RE: Cherry Creek Crossing Lot 111 Grading and Erosion Control Plan, El Paso County, Colorado (Kiowa Project No. 14028)

CDR-17-003 Cherry Creek Crossing Grading and Erosion Control Plan Review 1

Grading and Erosion Control Plans

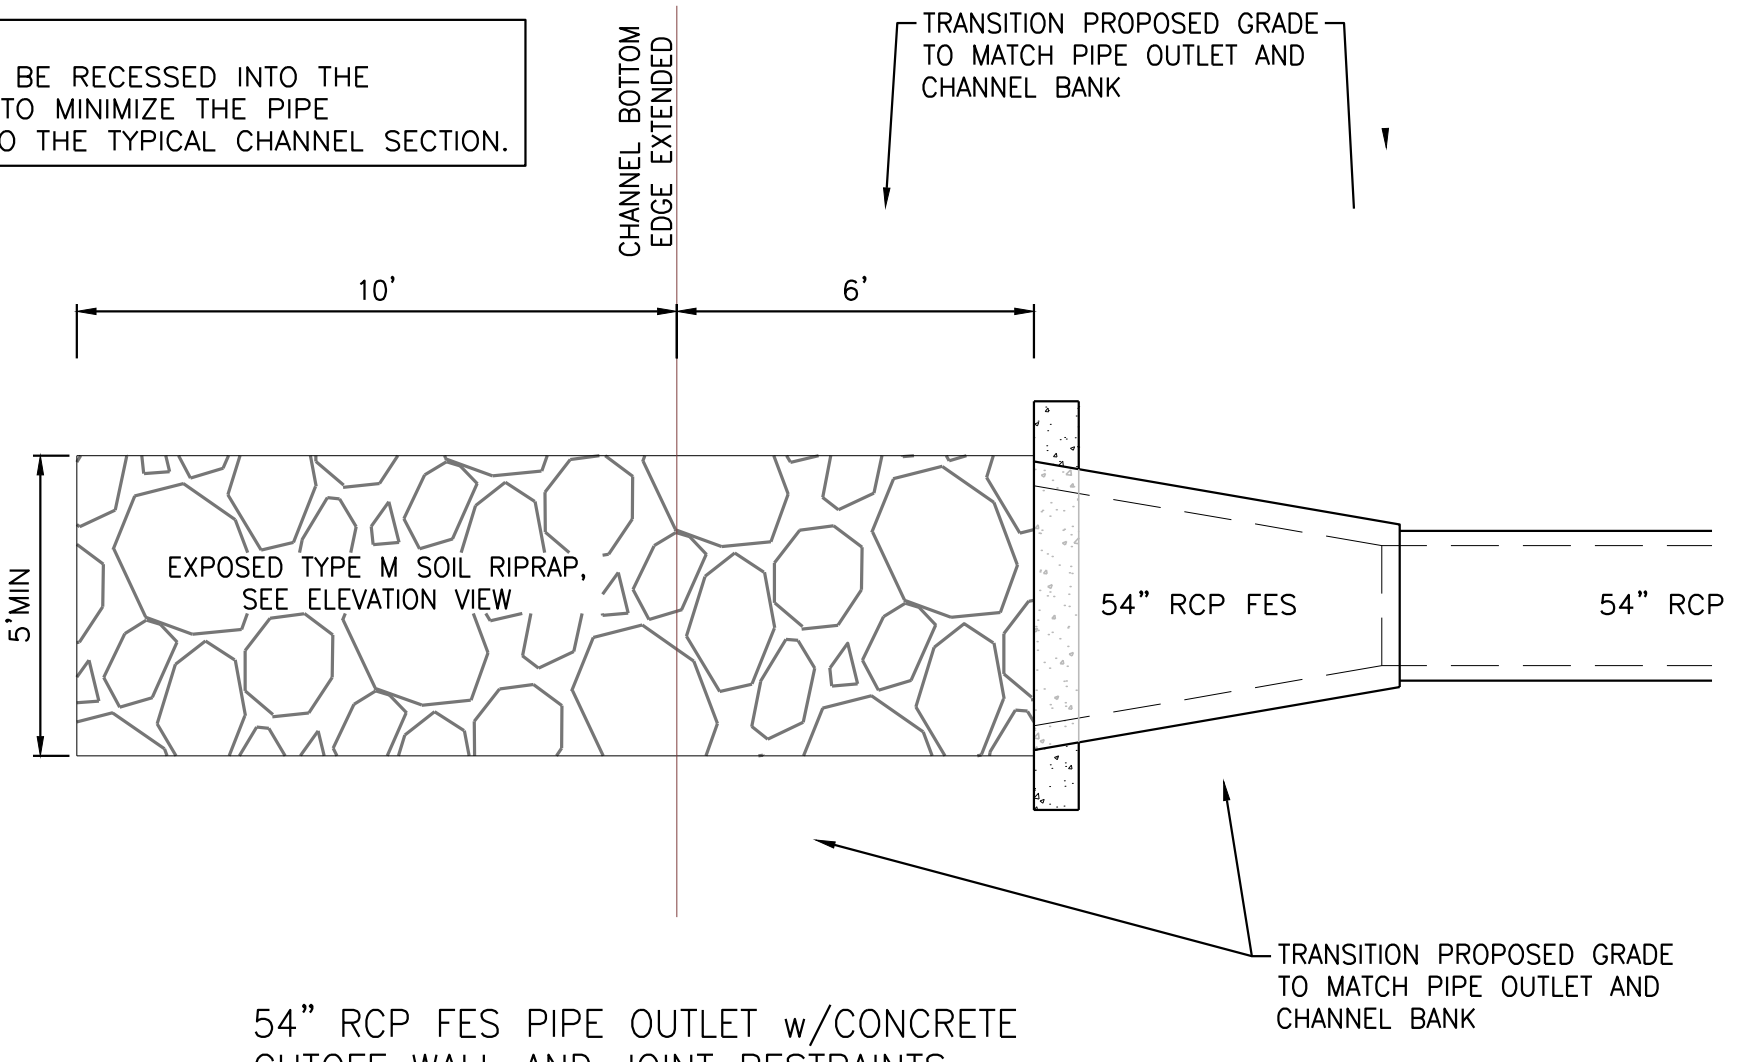
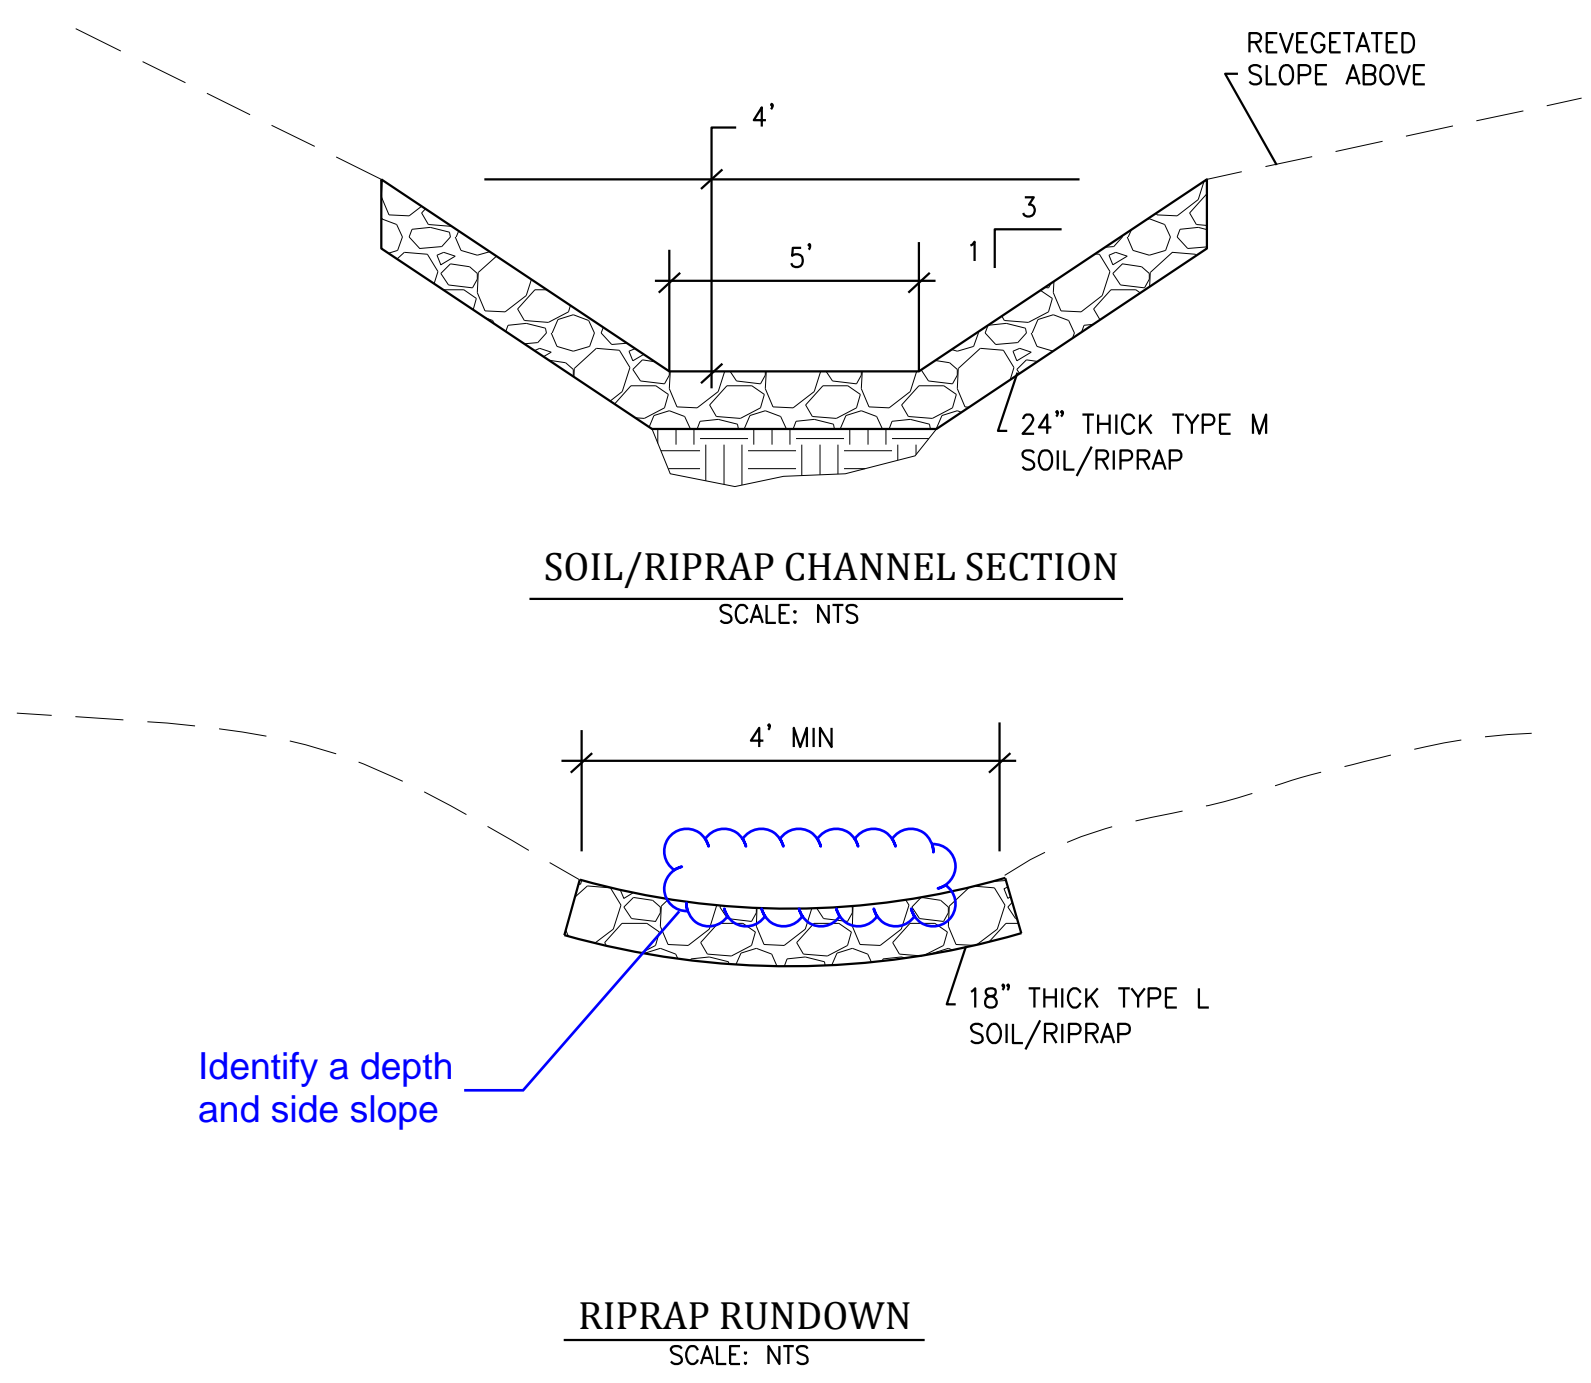
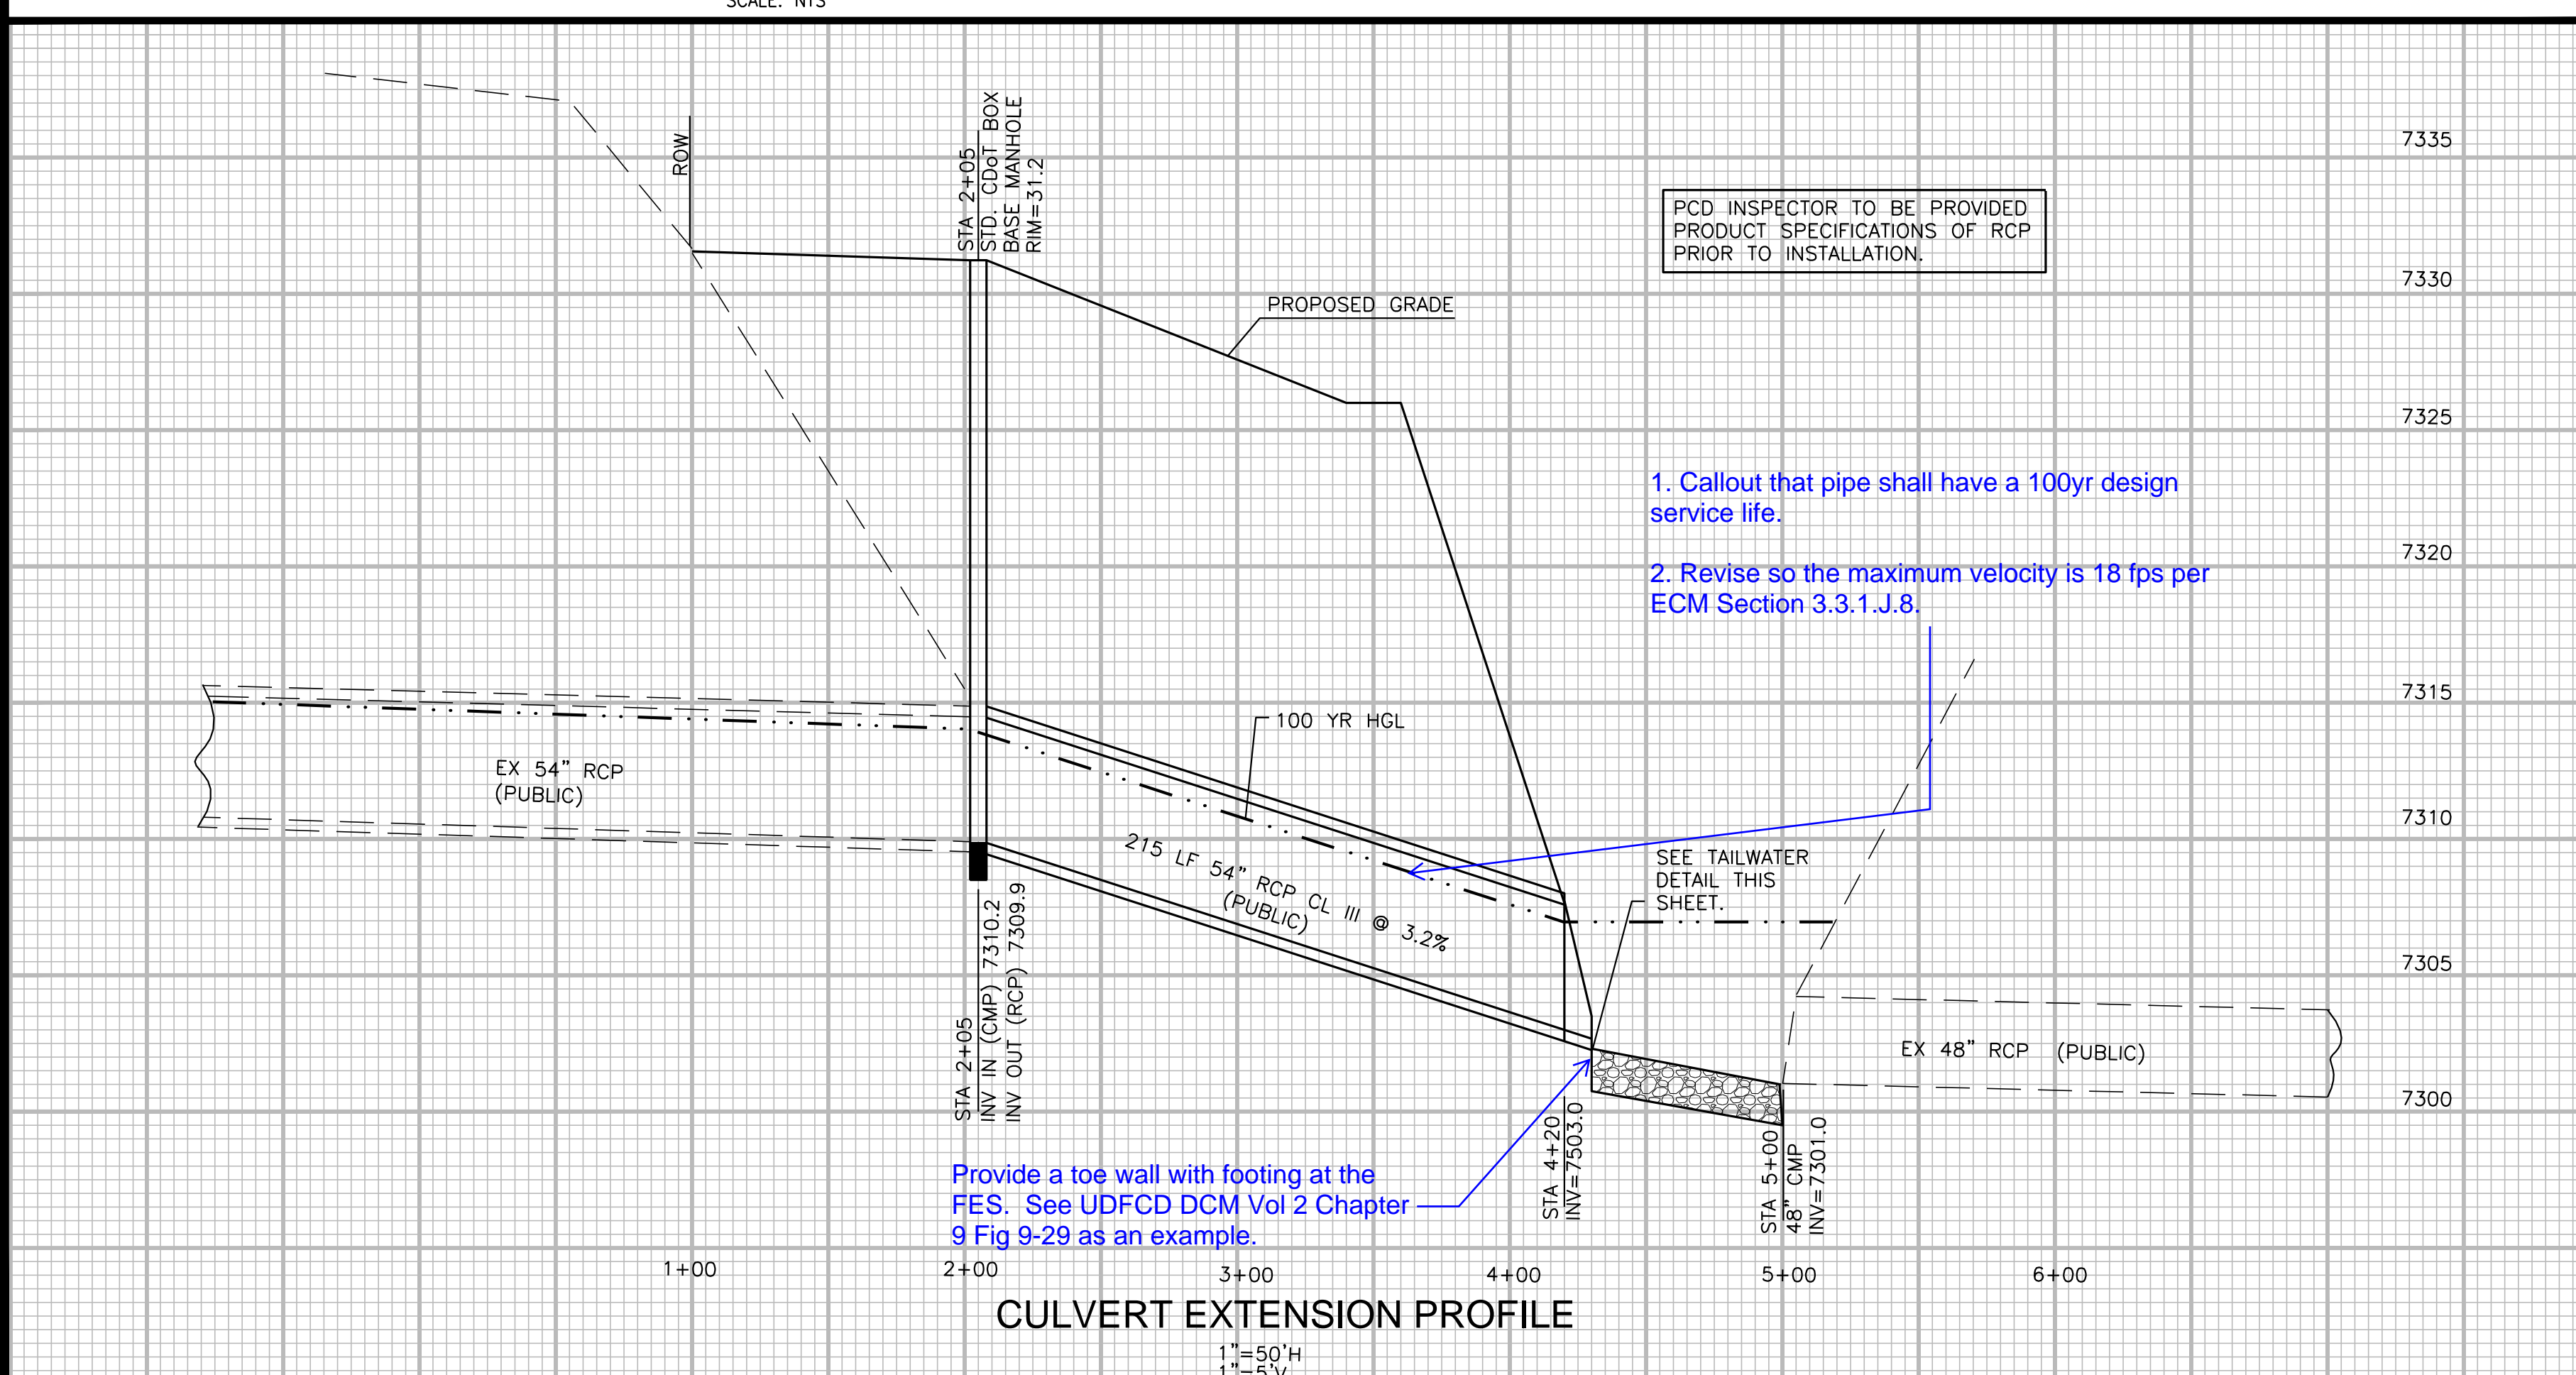
Sheet 6: All comments have been addressed with the following exception. The reviewer asked that the material's design life of the proposed storm sewer extension be stated on the plans. We are presently waiting for confirmation of the design life from the pipe manufacturer. This will be forwarded to the County when it is received. This drawing has been renumbered as sheet 3 on the revised drawings.
